KIRKLEES METROPOLITAN COUNCIL INVESTMENT & REGENERATION SERVICE

DELEGATED DECISION TO DETERMINE PLANNING APPLICATIONS

Reference No:	2024/62/90339/E
Site Address:	19, Cheviot Way, Upper Hopton, Mirfield, WF14 8HW
Description:	Erection of part two storey and part single storey front, side and rear extension with associated alterations
Recommending Officer:	Jennifer Booth

OFFICER REPORT

PROPOSED BLOCK PLAN
1:500

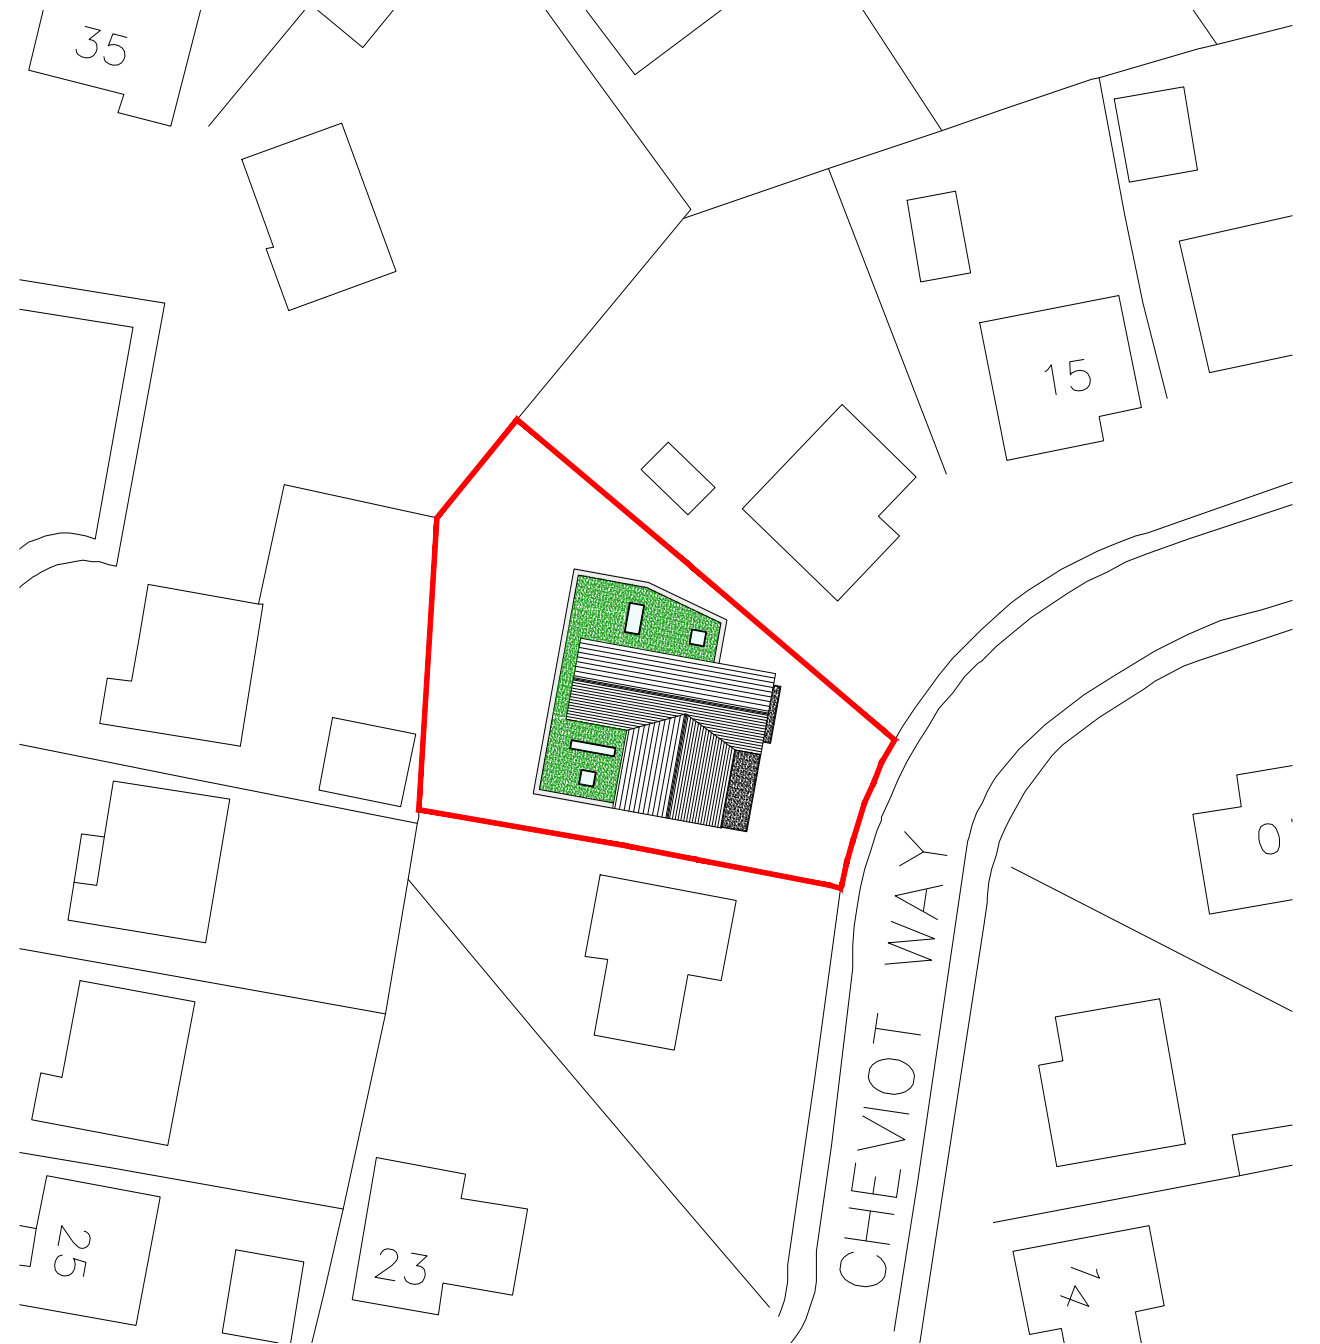
Kirklees Development Management Charter together with the National Planning Policy Framework and the DMPO 2015 encourages negotiation/engagement between Local Planning Authorities and agents/applicants, this is only within the scope of the application under consideration. The initially submitted plans raised concerns in terms of the balcony and potential loss of privacy. Amended plans were sought and

- Overdevelopment of the site,
- The works including the use of cladding would be out of character with the area,
- Loss of privacy for the neighbours to the rear as a result of the balcony,
- The extensions may lead to the occupants making more noise,
- The extensions would have an overbearing impact on the adjacent 21 Cheviot Way.

Although other matters may have been raised, such as accuracy of the block plan, only material planning matters can be considered. That being said, the officer has visited the site and has seen the relationships between the host property and the neighbouring dwellings including 33a Cheviot Way.

received which removed the walk out balcony and provide a Juliet balcony on the rear of the first floor rear extension. The amended plans were advertised.

Amended plans were requested and received through the course of the application to remove the terrace and balcony to the rear and replace it with a Juliet balcony, in the interests of visual amenity.
